Comment from Greenspace

This application is looking for the discharge of Condition 11 of application P/43/18/DOC imposed under P/76/16/PL.

APPLICATION P/43/18/DOC

Description of Works: Approval of details reserved by condition imposed under P/76/16/PL relating to condition 11-proposed wetland & associated landscaping.

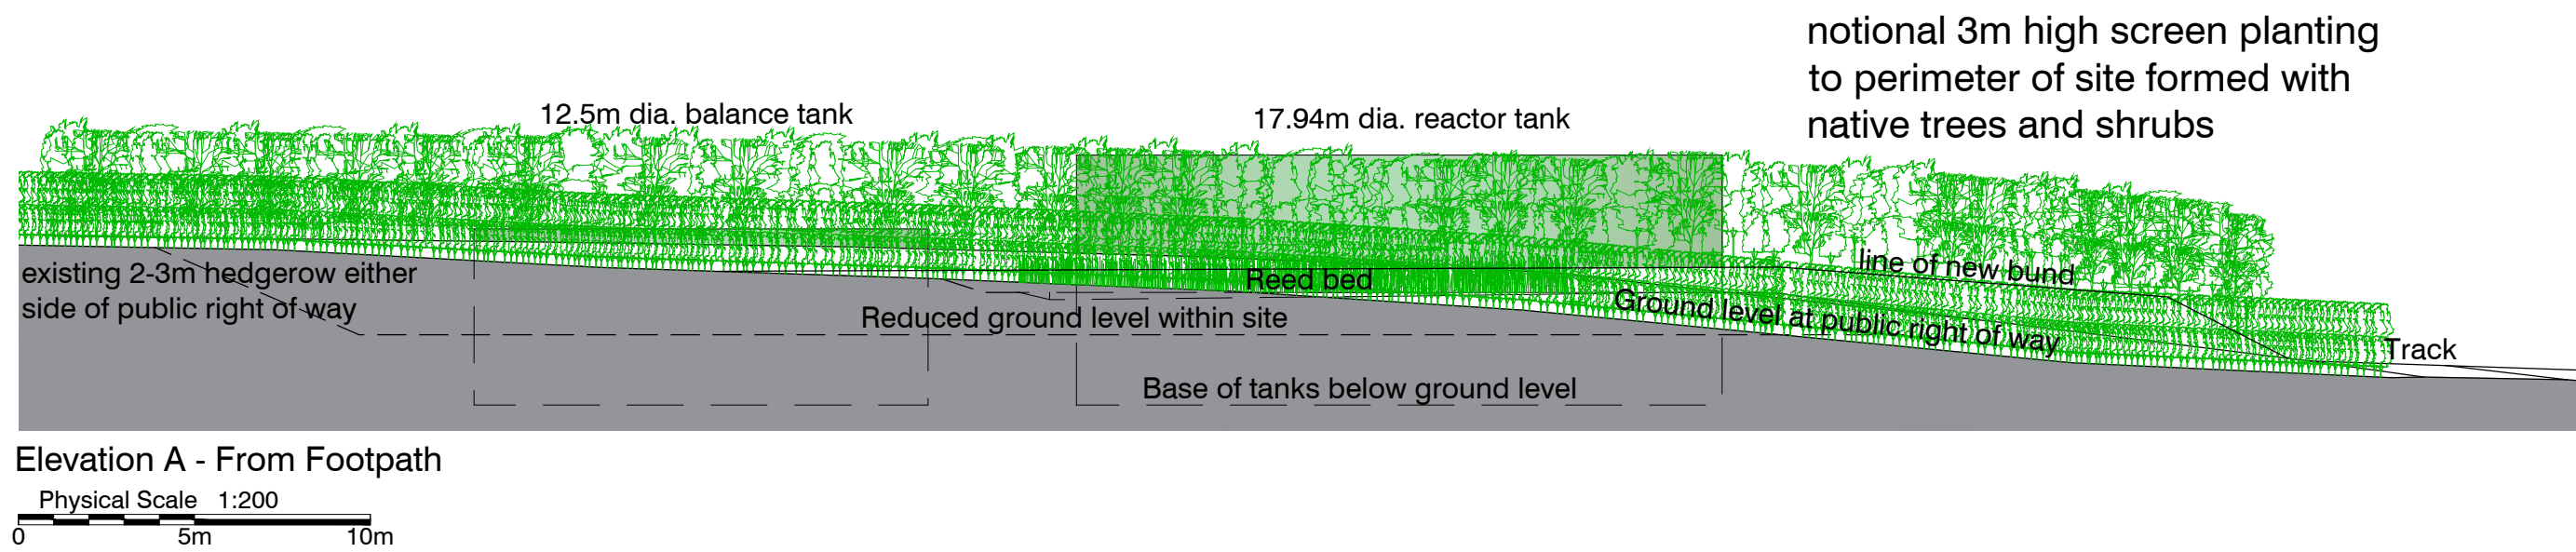
The information provided in Constructed Wetland Draft Layout dwg 017 rev 07 details an indicative screen planting to the perimeter which is shown as native planting. Whilst this is suitable for location the detail is not sufficient enough and needs to detail in plan form actual species choice, planting density and size at time of planting. This information needs to be submitted for approval before condition 11 re Landscaping can be considered for discharge.

We would therefore **not recommend the discharge of Condition 11 landscape scheme until the above information has been submitted for approval.**
